Mr A & Mrs S Scruton
Elm Cottage
30 The Street
Rustington
BN16 3NX

Our Ref: R/230/21/DOC

Town & Country Planning Act 1990 (as amended)
Town and Country Planning (Development Management Procedure) (England) Order 2015
Approval of details reserved by condition imposed under ref R/305/18/L relating to Condition No 3 -
materials, finishes and joinery.
Elm Cottage 30 The Street Rustington BN16 3NX

First Floor Front W1

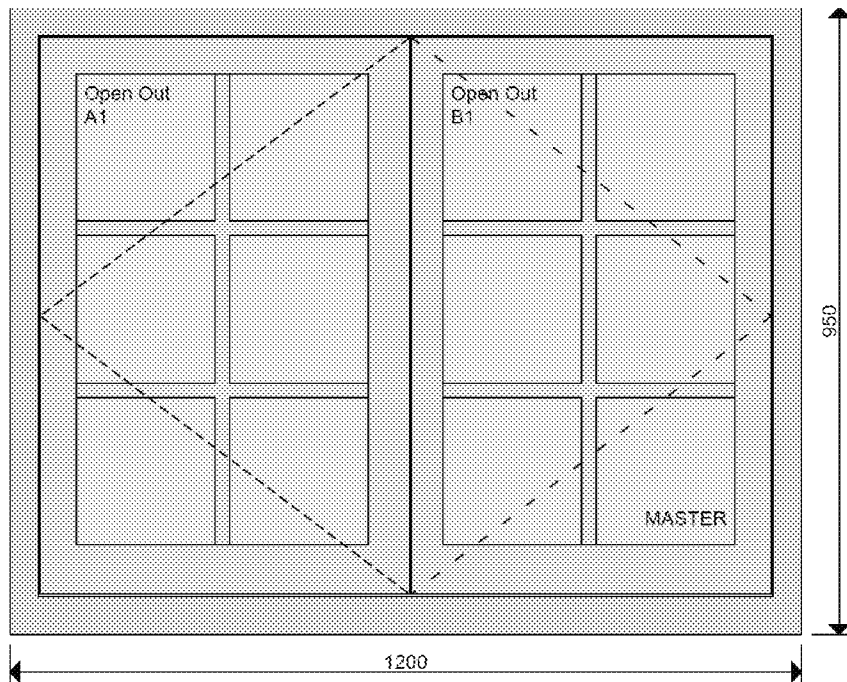
- Proposed units are of 'standard style and dimensioned' double glazing which is not appropriate within a listed building.
- Details provided are not clear as to whether the glazing bars will be internally or externally applied.
